Application: SSI 7485

I write regarding the proposed modification to M4-M5 Link, Mod 2 The Crescent overpass and changes to pedestrian infrastructure in North Annandale, Rozelle and Rozelle Bay Foreshore area.

Figure 4-4 Elevation: Indicative view of The Crescent overpass

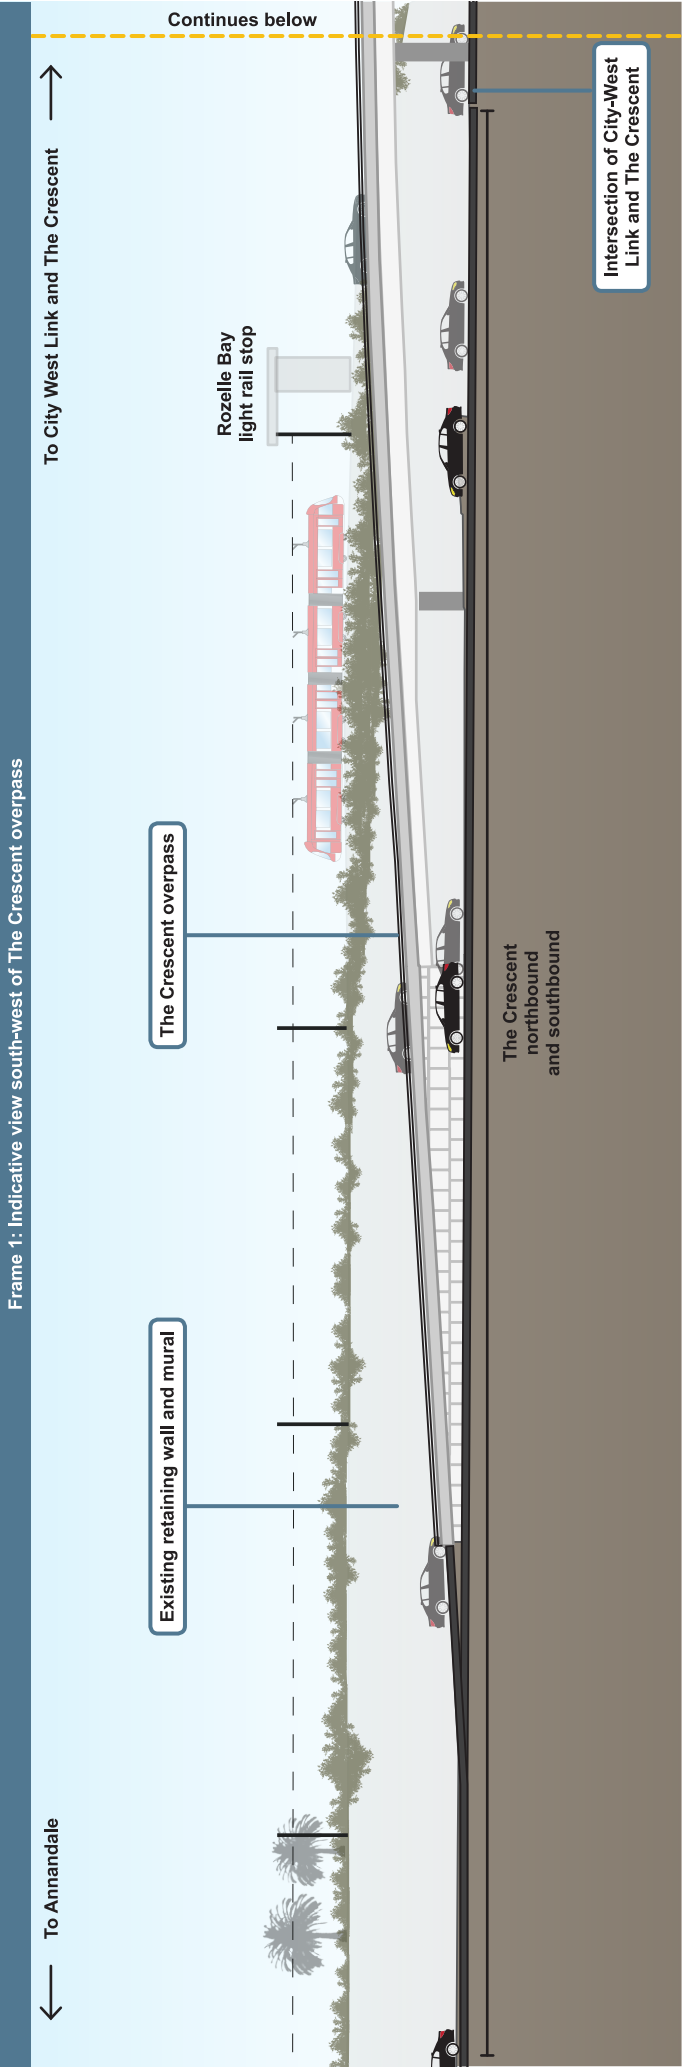
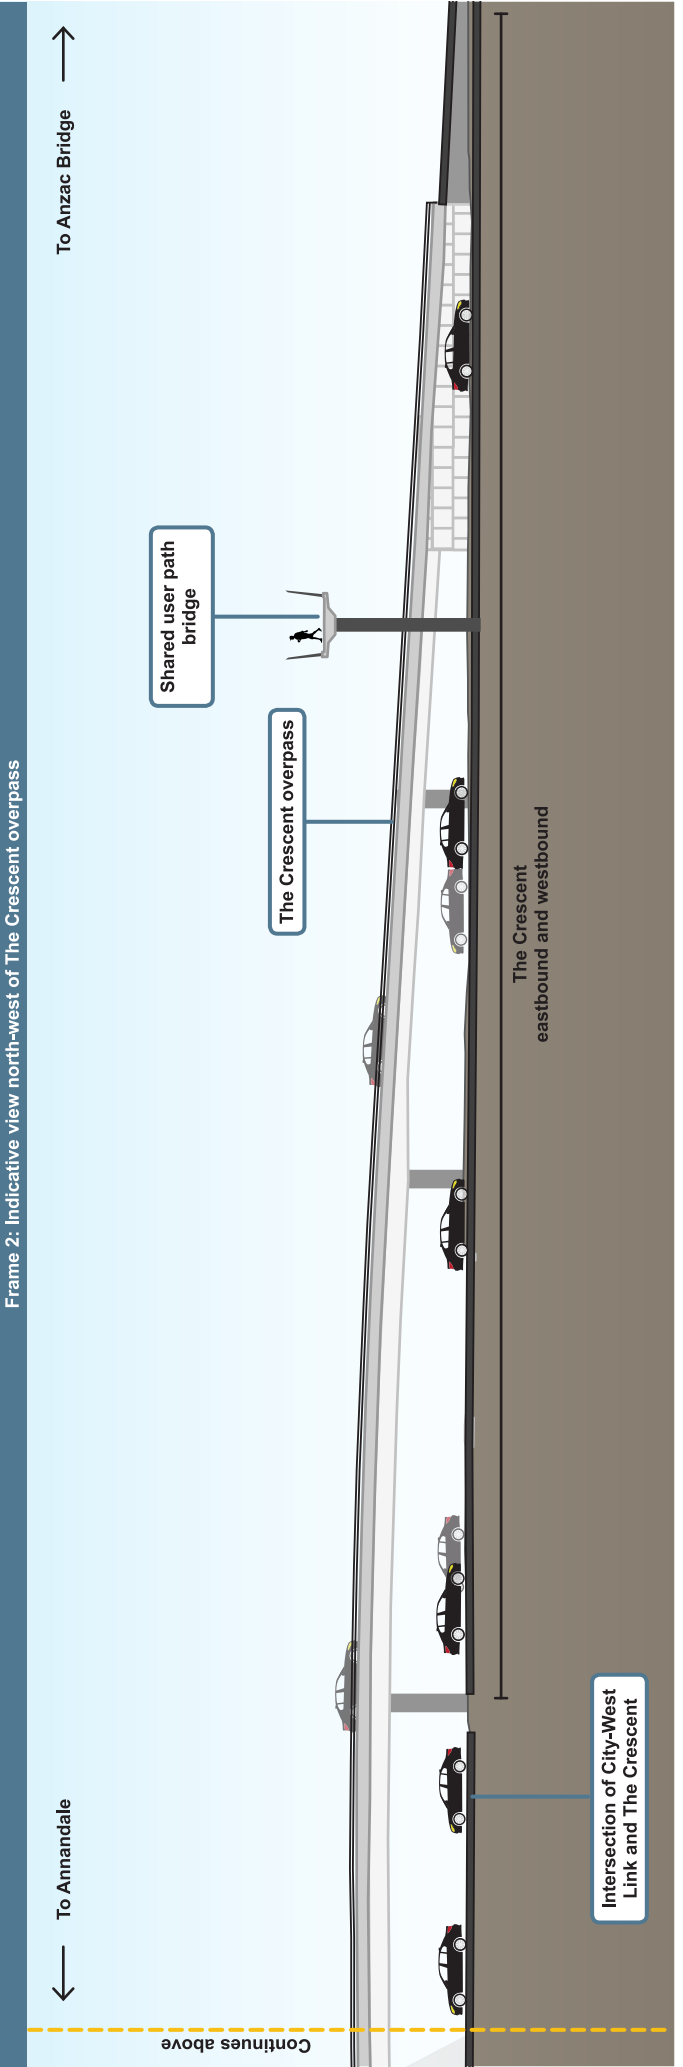
I request RMS work with the community to explore alternate design options to the proposed new car overpass design and the changed pedestrian and cyclist links. I am seeking the reinstatement of the safe, direct access from the approved EIS GreenLink to create a continuous green open space connection from the Rozelle Rail yards and Annandale to the foreshore. The GreenLink was more than just a walk way - it put people central to the design, maximising safety, and providing much needed accessible open space for the community now and into the future Bays Precinct design.

- Instead of an overpass from ~~port~~ crescent to city west Link, how about an underpass. Yes this is more costly, but in the longterm will pay dividends for the community.
- Lets not just think short term on this. This is a legacy project for not only the inner west community but all of Sydney.
- Integration with transport links and new bays precinct should be number ① priority

Figure 4-6 Elevation: Indicative view of Rozelle Rail Yards Pedestrian and Cycling Green Link

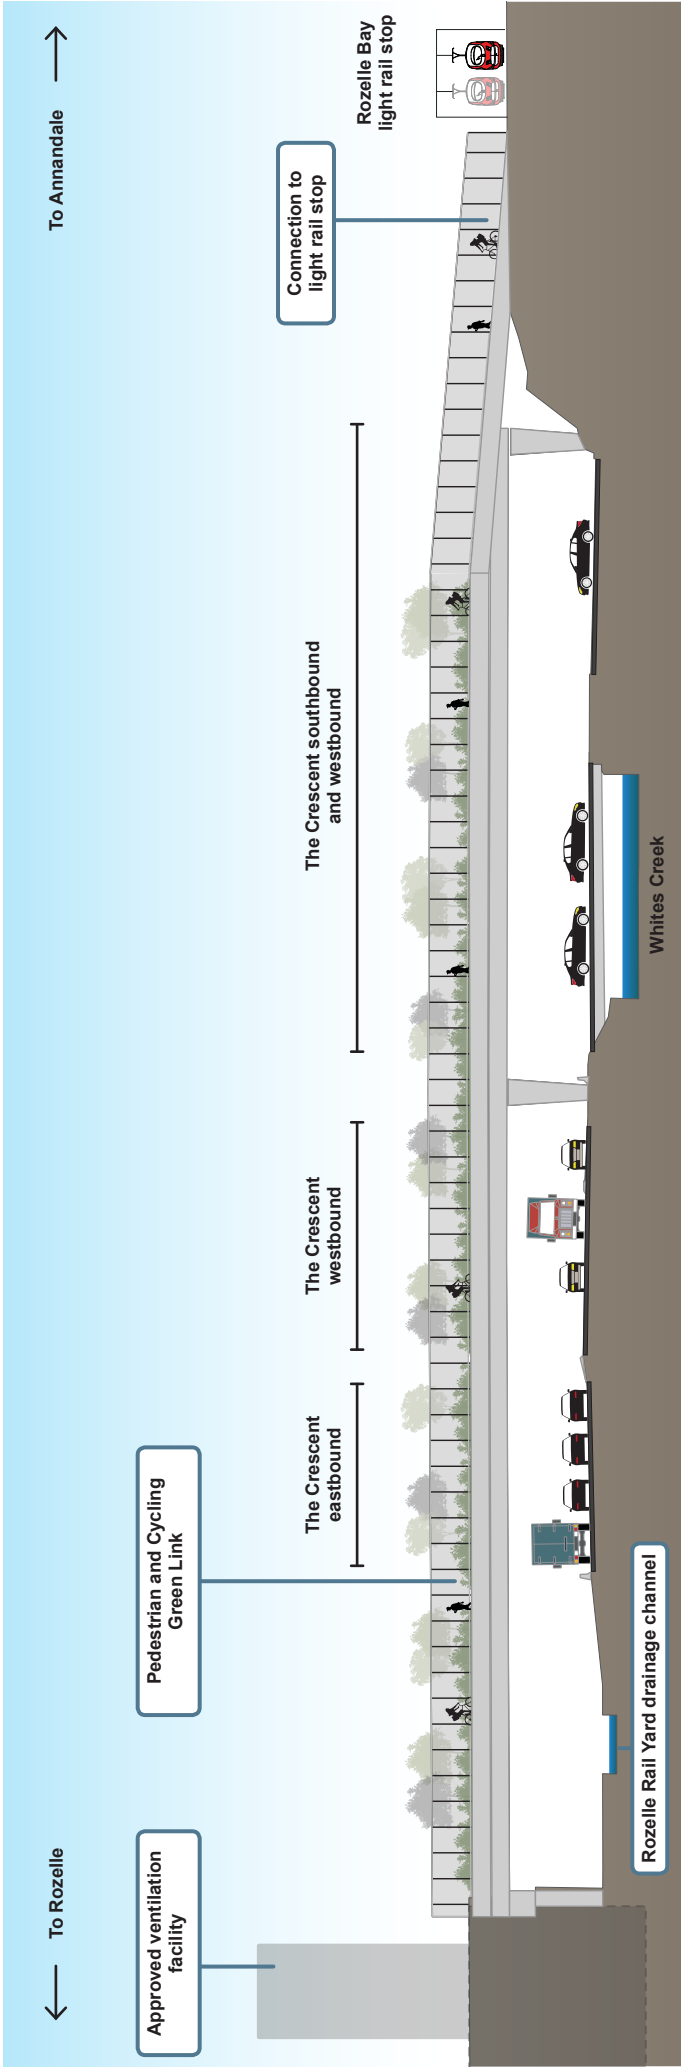
- Reinstate the GreenLink connecting communities and green open space from Rozelle to Bicentennial Park
- Relocate and design pedestrian and cyclist connections that are continuous, safe and direct.
- Design the modification infrastructure and active links in response to the character of the suburbs, the location of the foreshore and it's potential future development.
- Provide pedestrian and cyclist paths that maximise people safety and do not force them onto busier streets, unsafe concrete plazas and caged walkways.
- Integrate active and direct connections to all active transport - including the future Metro West and Foreshore Ferry Wharf
